THE HILLS SHIRE COUNCIL

Your Ref: SSD 7787

K-6 Public School – Nos. 21-23 Fairway Drive, Kellyville

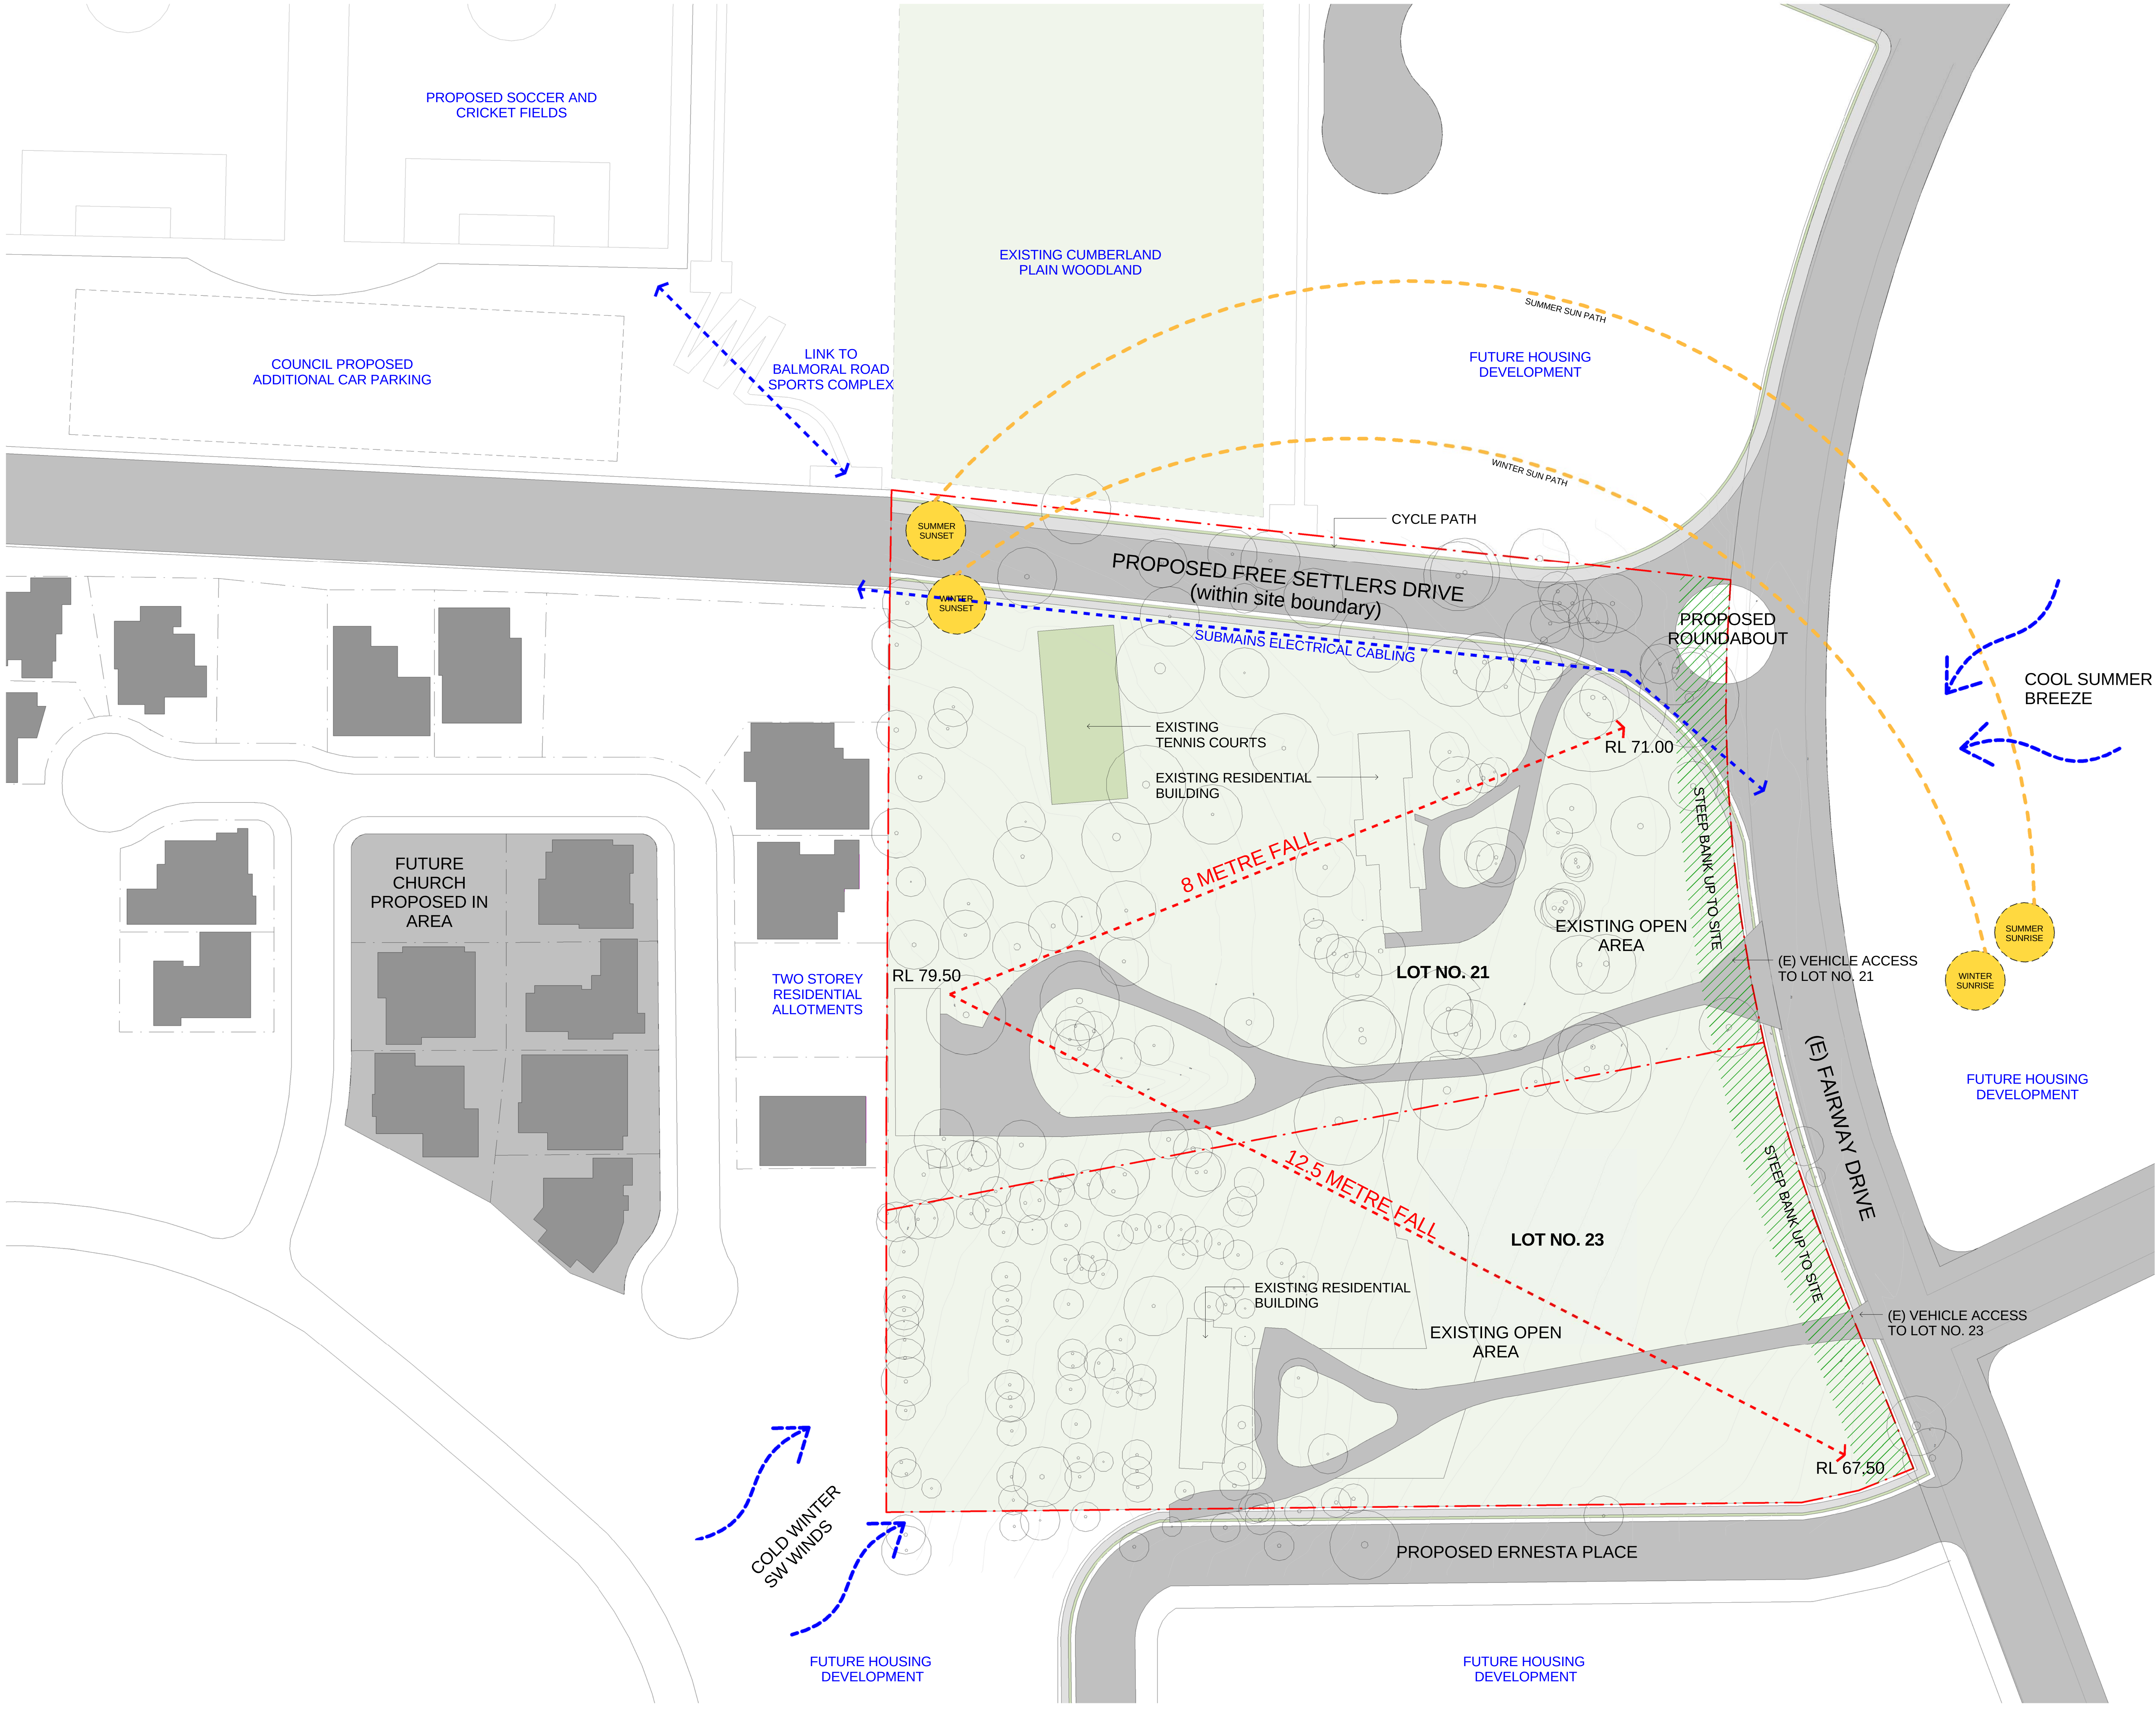
As you are aware, Council staff provided comments in relation the Department of Planning and Environment's request for input for the Secretary's environmental assessment requirements (SEARs) prior to lodgement of the Application. As identified in those comments, concern was raised in relation to parking. The reliance on on-street parking is considered unsuitable given the size and location of the school. Council's Development Control Plan (Part C Section 1- Parking) requires that on the site parking be provided at a rate of 1 space per employee plus 1 space per 30 students enrolled, for visitors and/or parent parking. It is noted that no on-site parking has been provided for this proposal.

Contrary to position outlined in the application, it should be noted that no agreement has been reached in relation to the school utilising proposed parking areas within Council's Reserve adjacent to the site and any reliance on that parking or parking being used by the school is not supported.

In addition, no details have been provided regarding a kiss and drop area. It is assumed that these areas are not shown as the public road frontages are used exclusively for parking. Kiss and drop bays if designed appropriately provide for a safe and efficient method of dropping or picking up of students. This application should be redesigned to implement best practice principles in relation to kiss and drop.

Given the issues raised above, it is considered that the proposal warrants amendments to the design to include on-site parking and a formal kiss and drop area. Should the Department be of a mind to support the application, conditions can be provided at this time on request.
